From:
Sent: 12 November 2023 15:50
To: DCAdmin
Subject: Planning application 2023/62/92966/E

Planning application 2023/62/92966/E Land to the rear of, 271, Cliffe Lane, Gomersal, Cleckheaton, BD19 4SB

Planning application 2023/62/92966/E. Objection.

CLIENT	QUARTERS GOMERSAL
PROJECT	CLIFFE LANE, GOMERSAL
TITLE	SITE PLAN LAYOUT
DRAWING NO.	1694-101
REVISION	F
SCALE	1:500 @ A1
DATE	01.23
DRAWN BY	BC
CHECKED BY	-

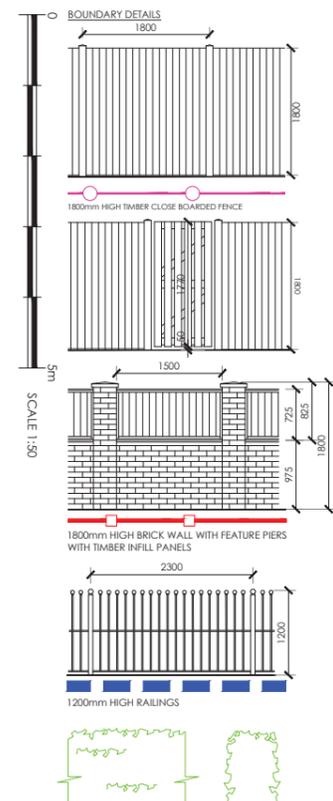
My main objection to the application is that of the inclusion of 3 storey or split 2/3 storey houses in the plan.

In my view, houses of this height would be inappropriate for inclusion in a site which is in a semi rural area, next to Green Belt.

In the present plan submitted to Kirklees, out of the 87 dwellings, there are 31 three or 2/3 storey houses. Of these 14 are on the perimeter of the site and 10 next to, or adjacent to Ferrand Lane and Gomersal Methodist Church Walkers using the public right of way down Ferrand Lane would be walking past these three storey houses towering above them.

The site can be seen clearly from the graveyard behind Gomersal Methodist Church, a heritage asset. Any building would interfere with the, at present, peaceful rural view but 3 storey buildings would be particularly intrusive. Although examples can be found of three storey buildings in rural areas, in my view they are more suited to townscapes. Indeed, even the street name given to the road on which the houses are to be situated is Mews Court, a name which brings to mind mews houses in central London. It is alarming, therefore, to see on the plan, that 3 storey or split 2/3 storey houses are situated, for ten plots, on the perimeter of the site next to or near Ferrand Lane, and in the case of plots 84,85,86 and 87, at the very top of the incline where they would be most visible from Ferrand Lane and Gomersal Methodist Church.

This is not the case, there are fourteen 3 or 2/3 houses on the site boundary.

Quite rightly, 2 storey plots have been positioned at the south side of the site to be in scale with the houses on Cliffe Lane. However positioning nearly half of 3 or 2/3 plots to the boundaries is at odds with the proposals outlined in the Planning Statement.
